From: Amanda Scholes on behalf of Planning.Responses
Sent: 21 May 2019 09:07
To: Planning Scanning
Subject: FW: Description of the application. RE: F/30/18/PL - Multispan polytunnels at Wicks Farm.

Subject: F/30/18/PL - Multispan polytunnels at Wicks Farm.

1. Can you clarify the description. It appears you are applying for two not three multispans polytunnels and associated works;

WICKS FARM

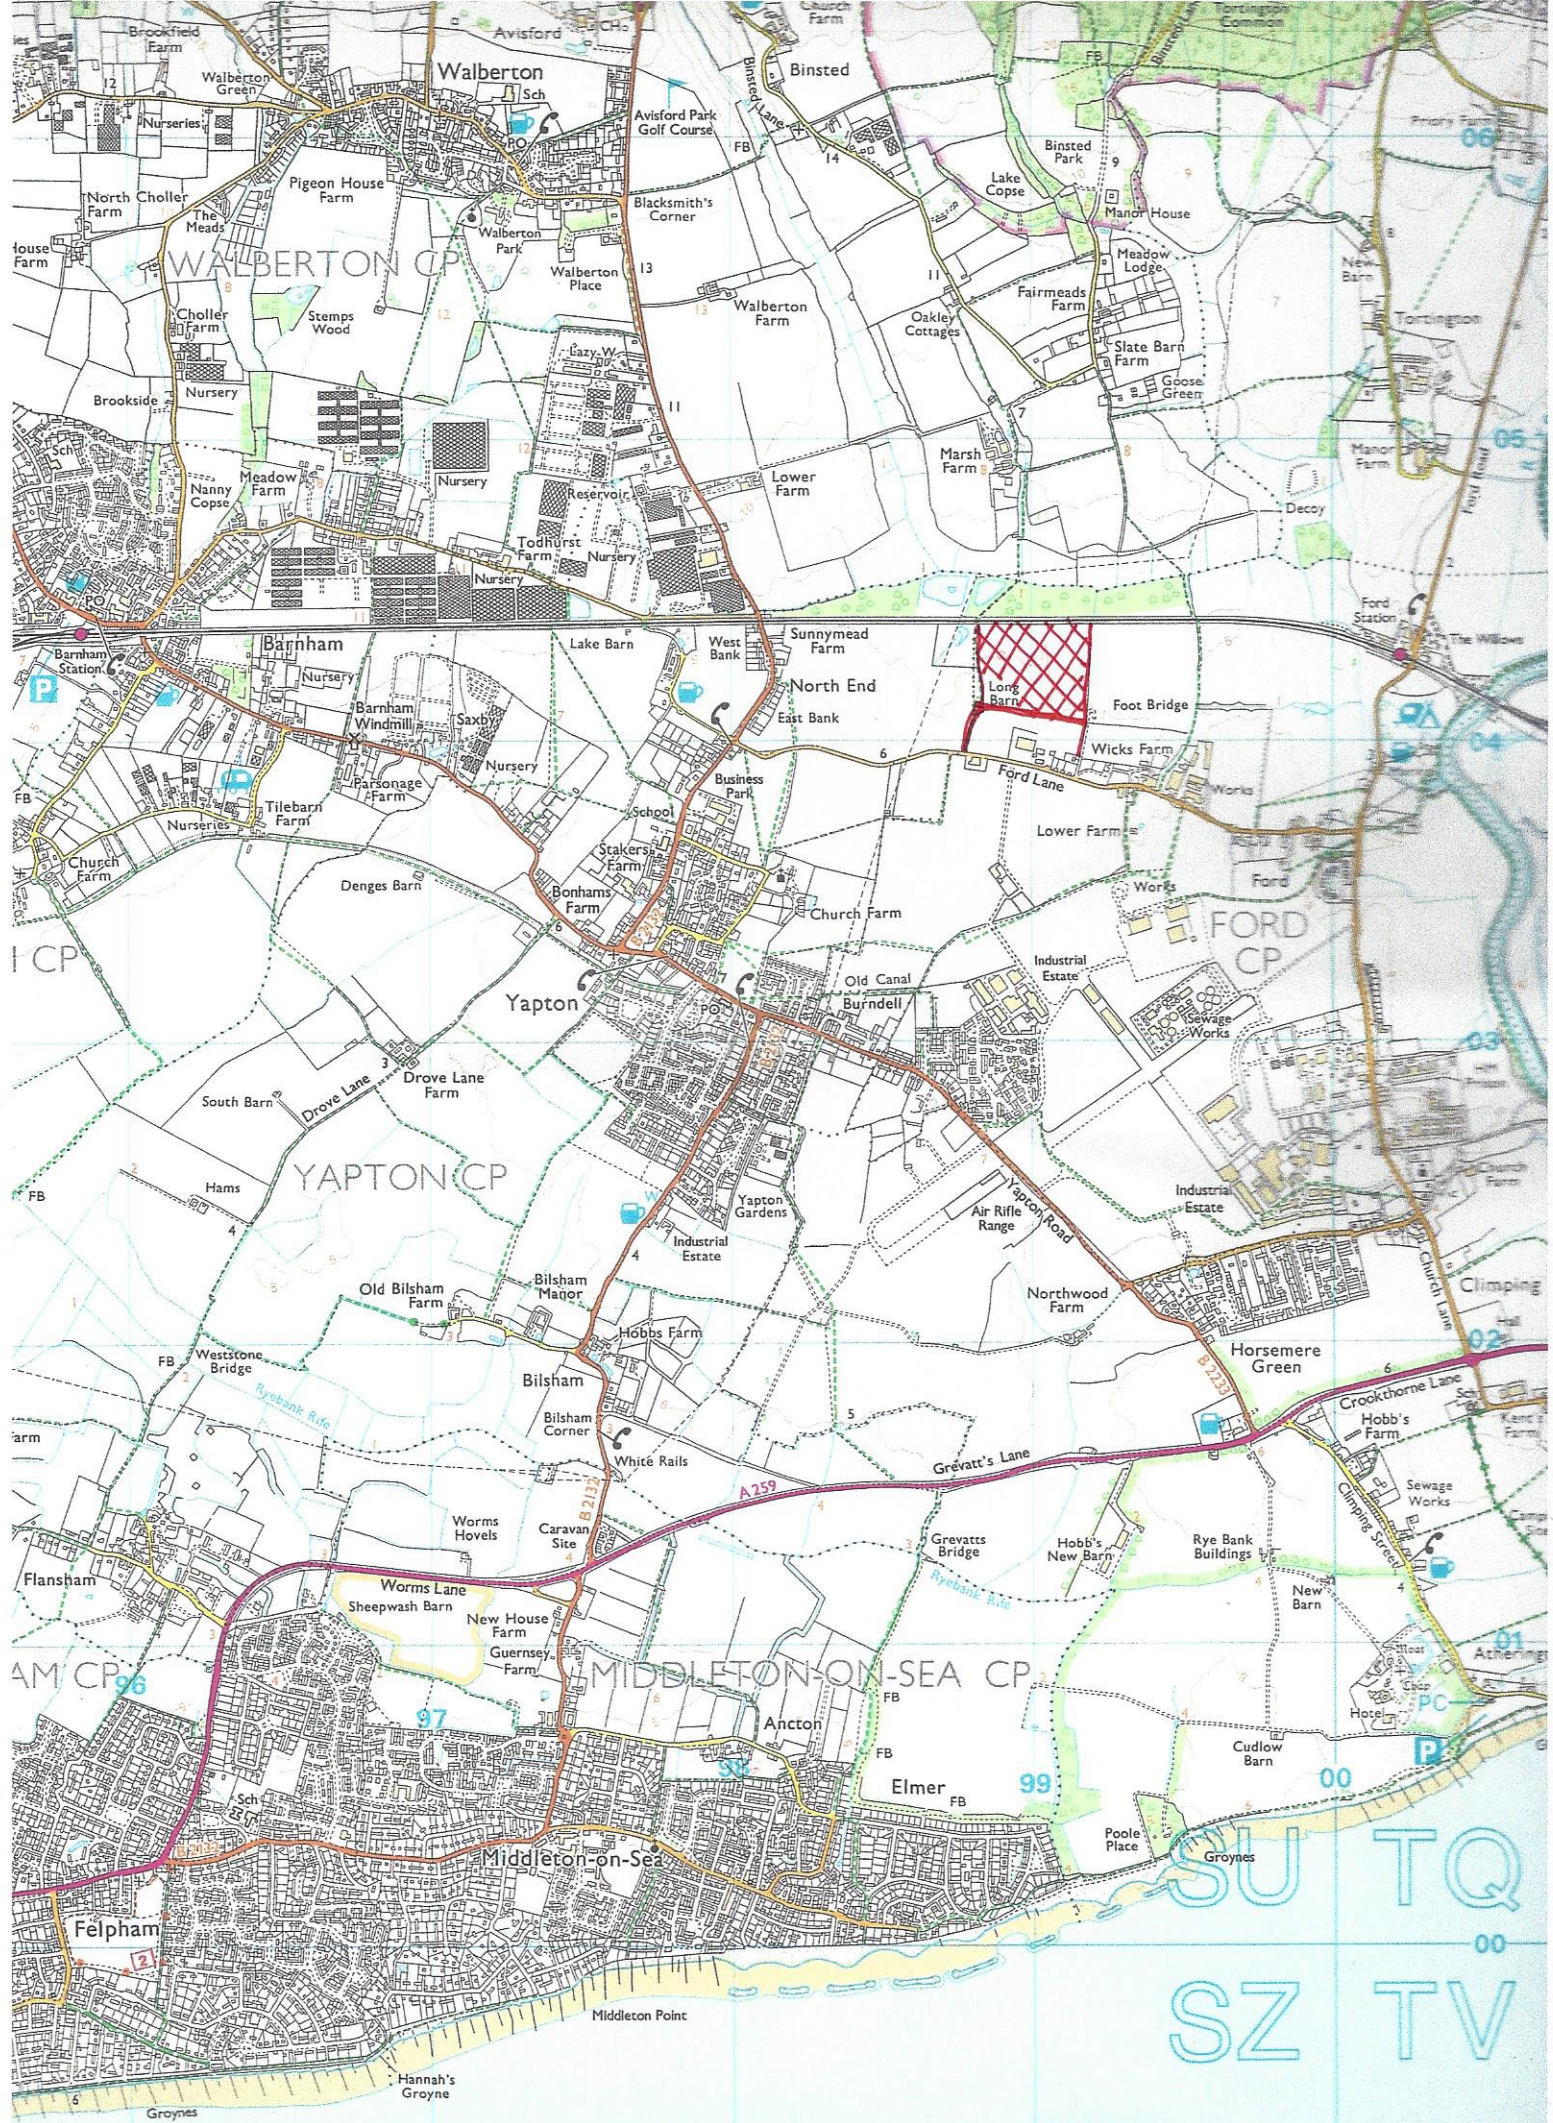
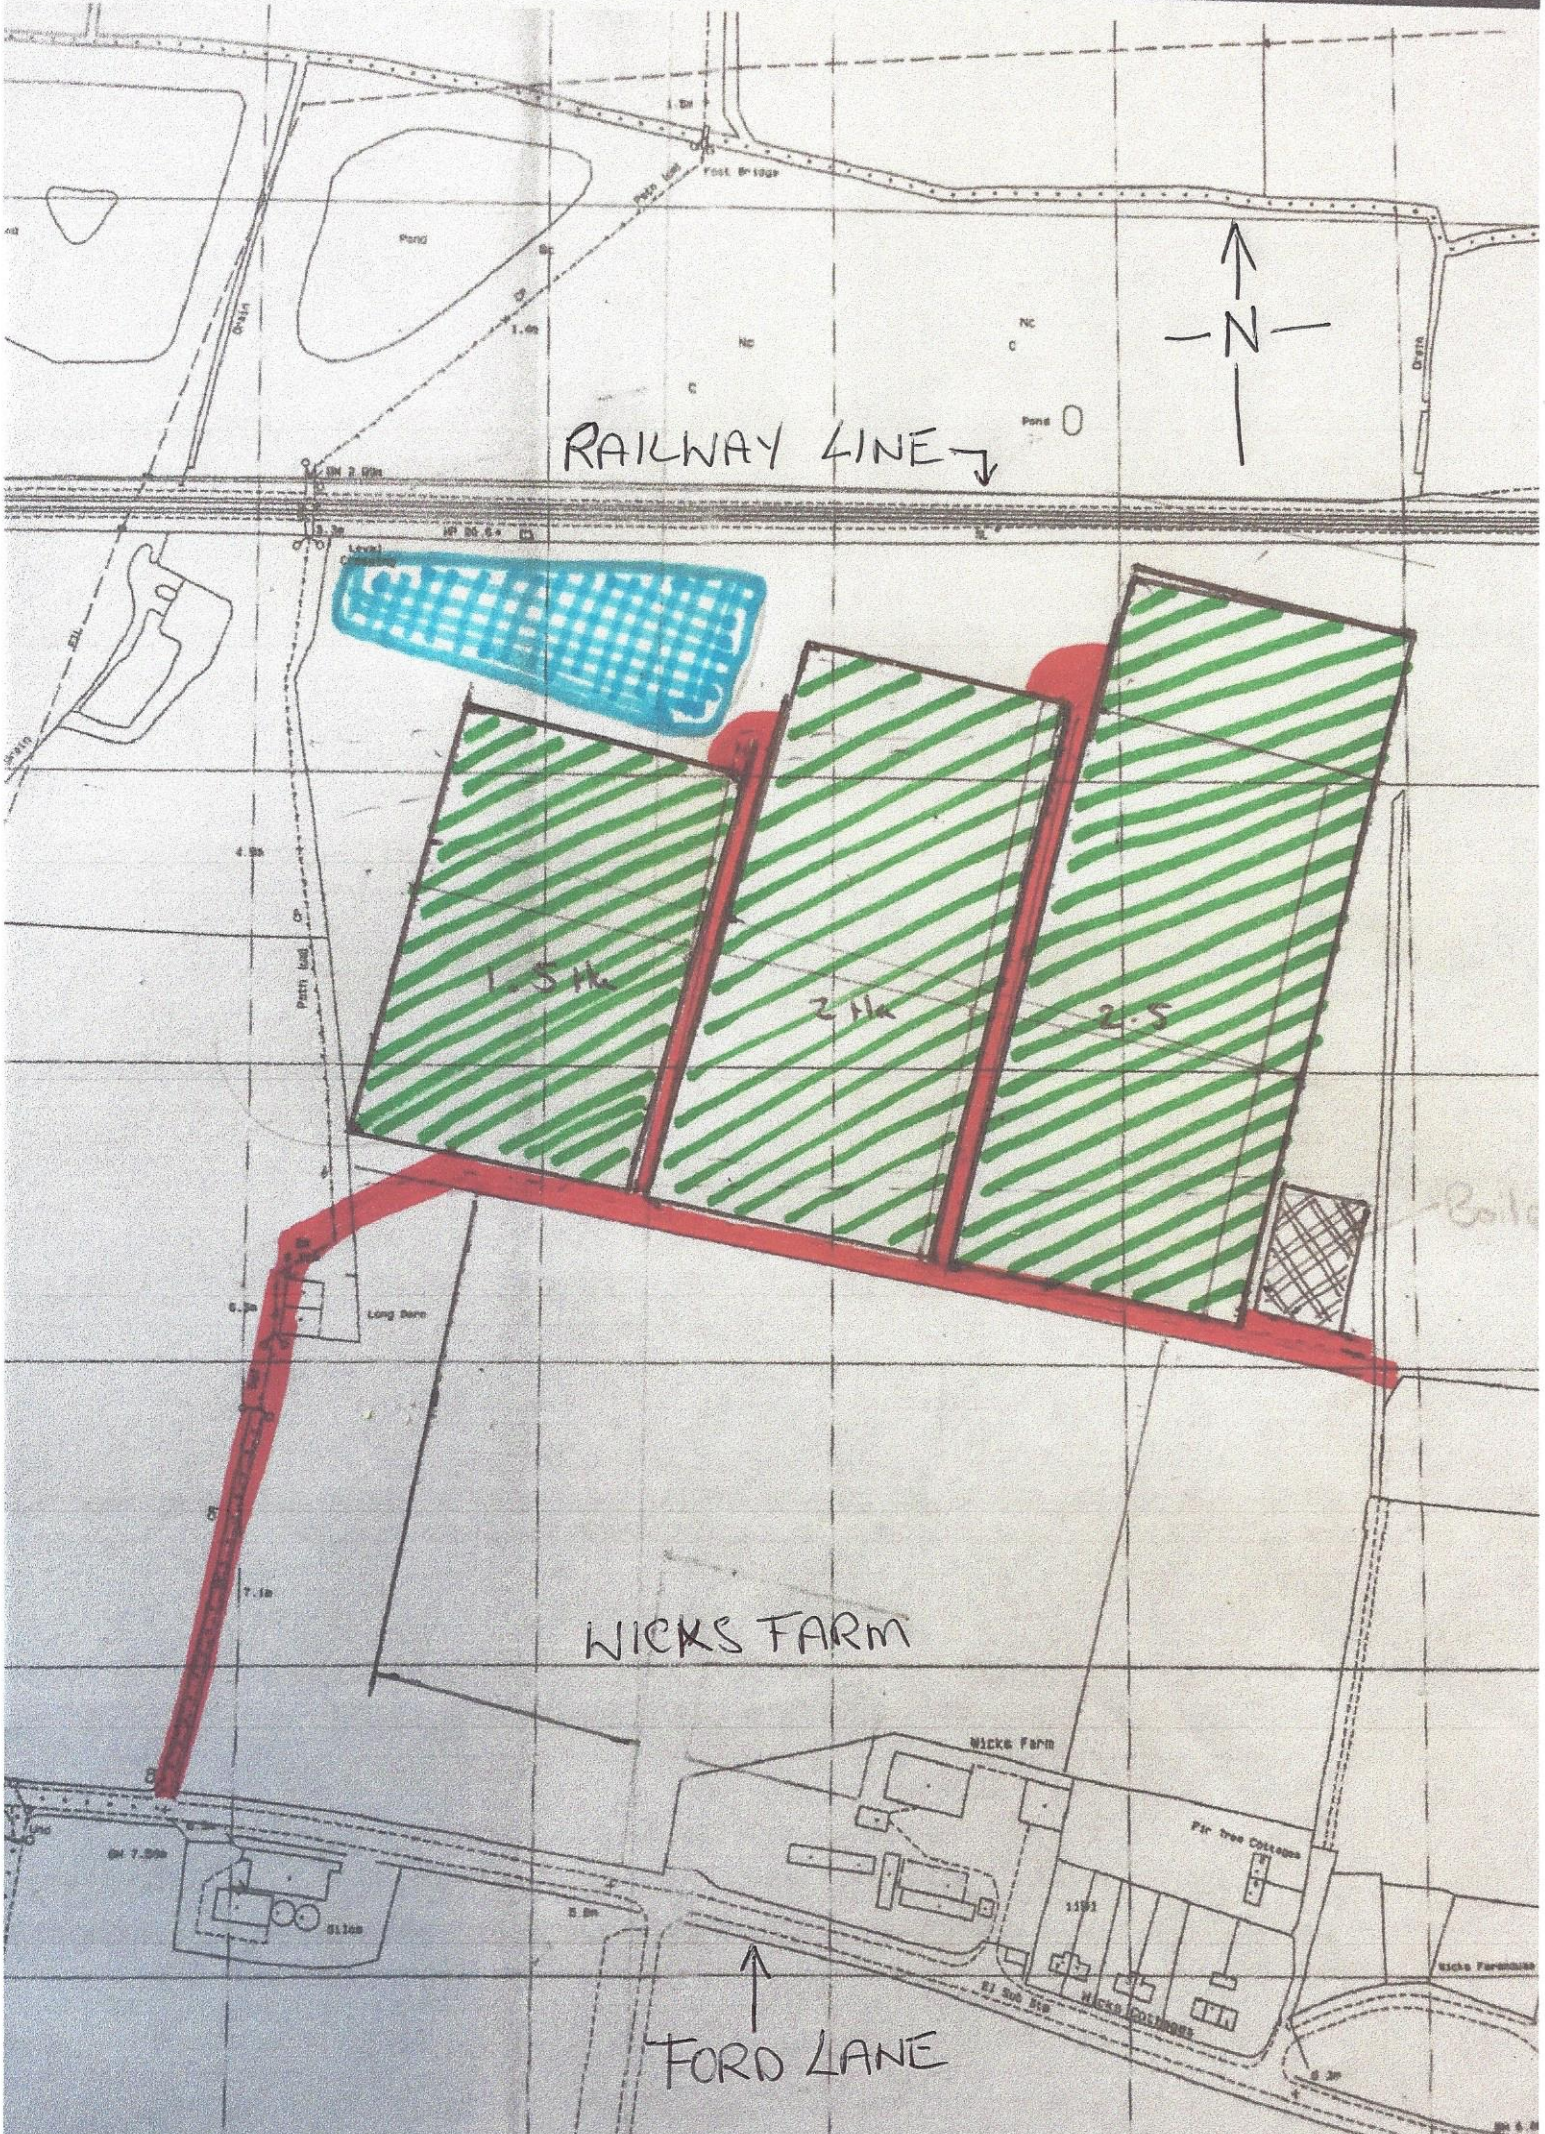
3. Can you amend the block plan to show where the parking for;

Light Goods Vehicles

Motor Cycles

Disability Spaces

Cycle Spaces

Mini bus spaces

4. Please confirm the final block plan include all lagoons/ drainage ponds as shown on the FRA appendices received on 11th February 2019.

The parking areas for various vehicles will be shown on the updated block plan to follow shortly.

All lagoons and drainage ponds will be shown on the updated block plan to follow shortly.

Ancillary Building One

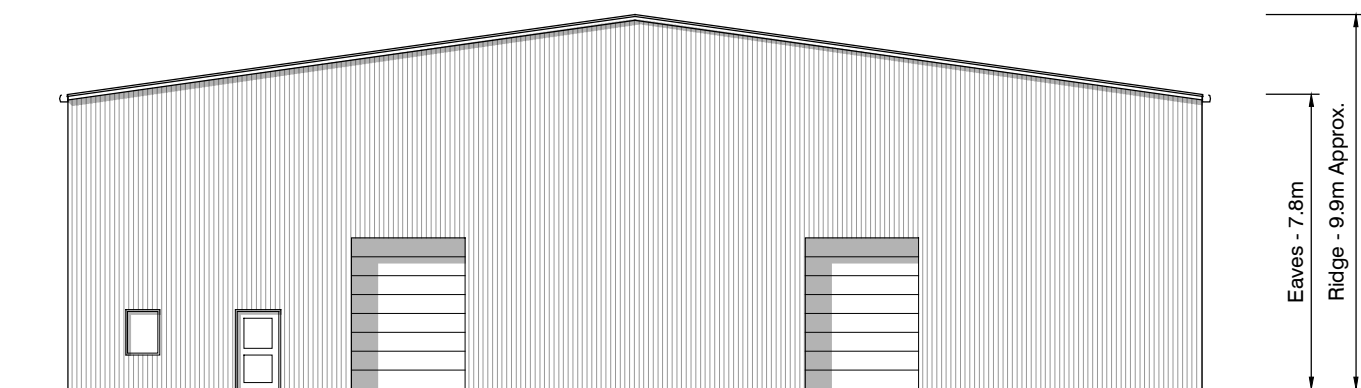
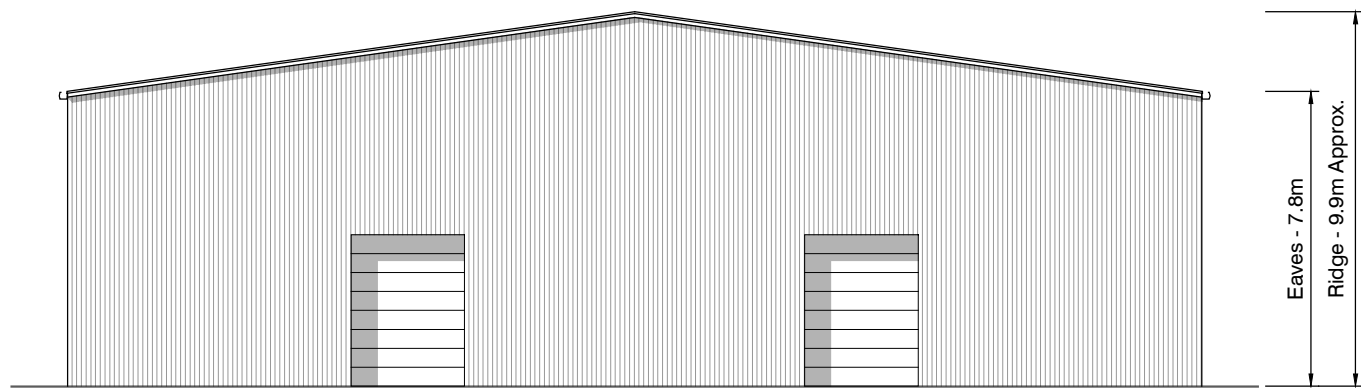
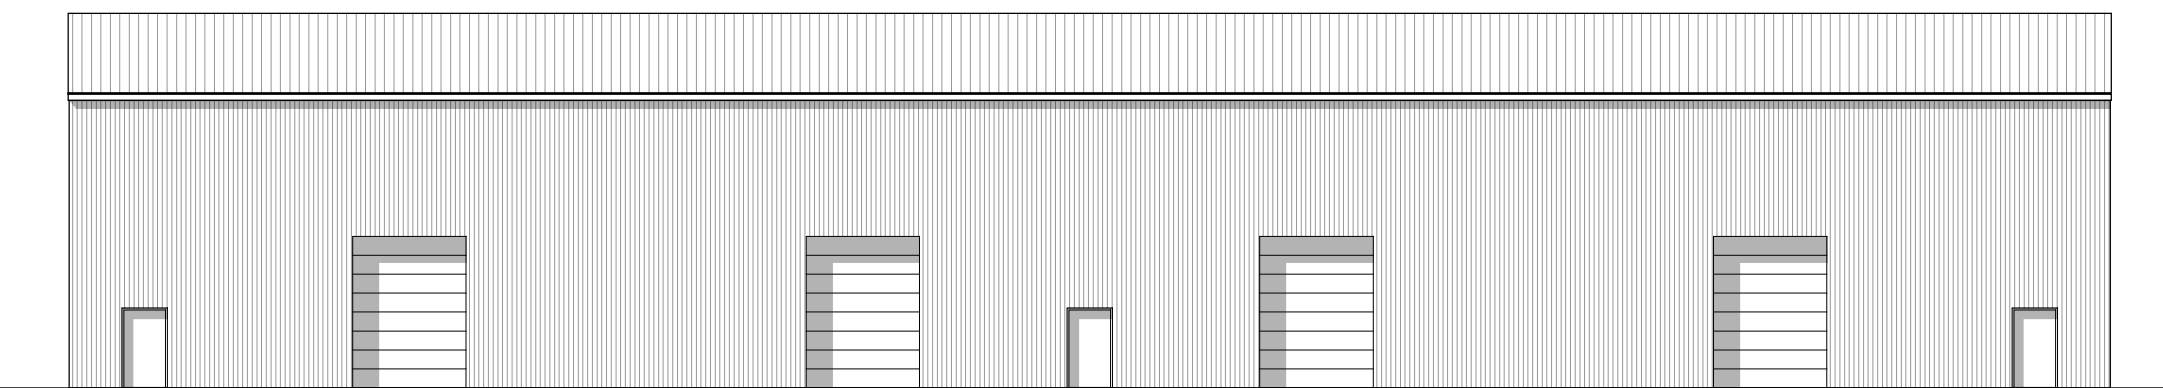
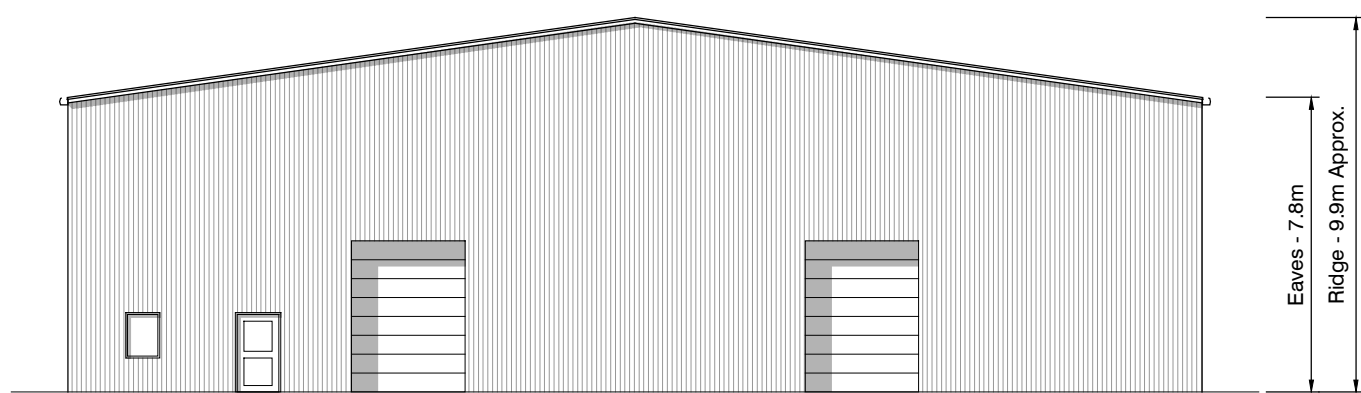
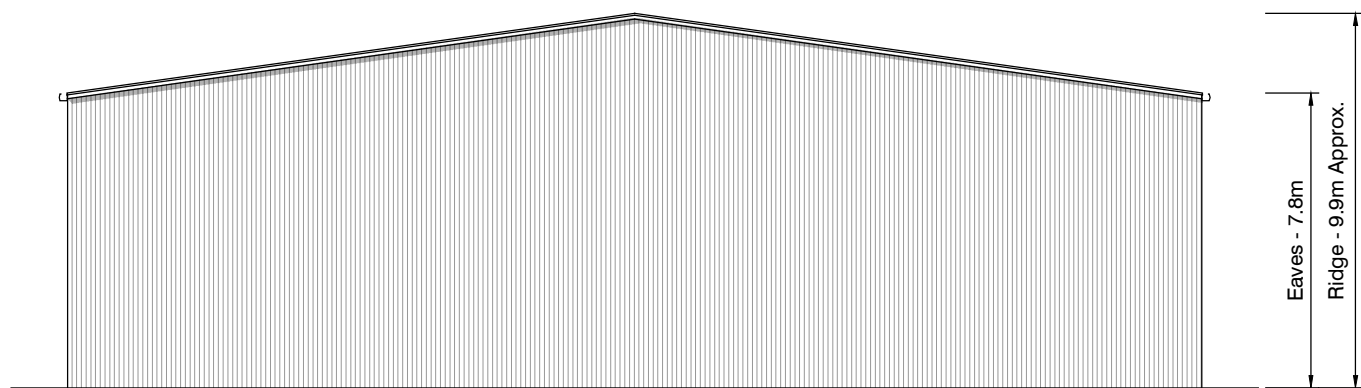
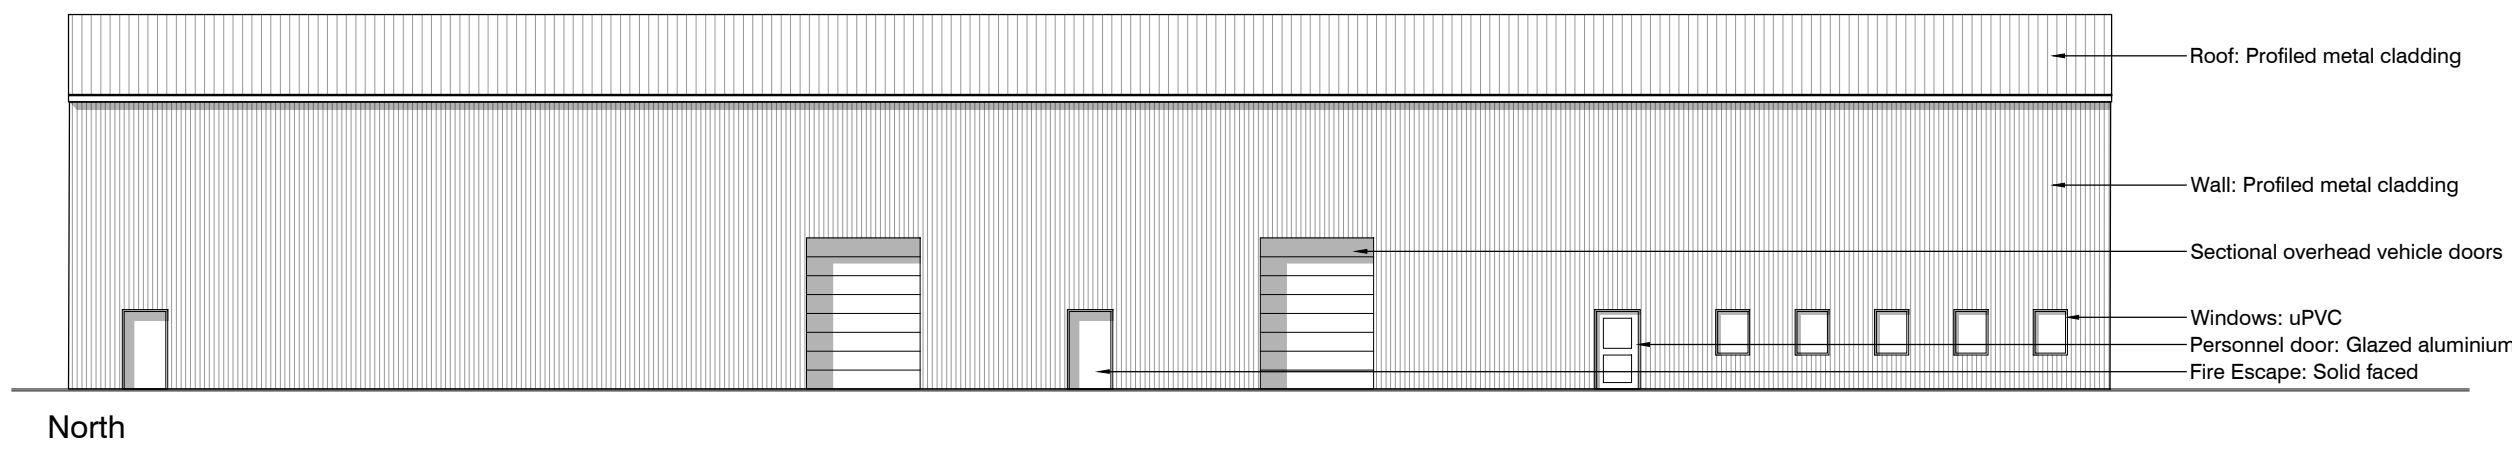
2. Can you provide elevation plans of the ancillary buildings.

The elevation drawings for the ancillary buildings will follow shortly in a separate email.
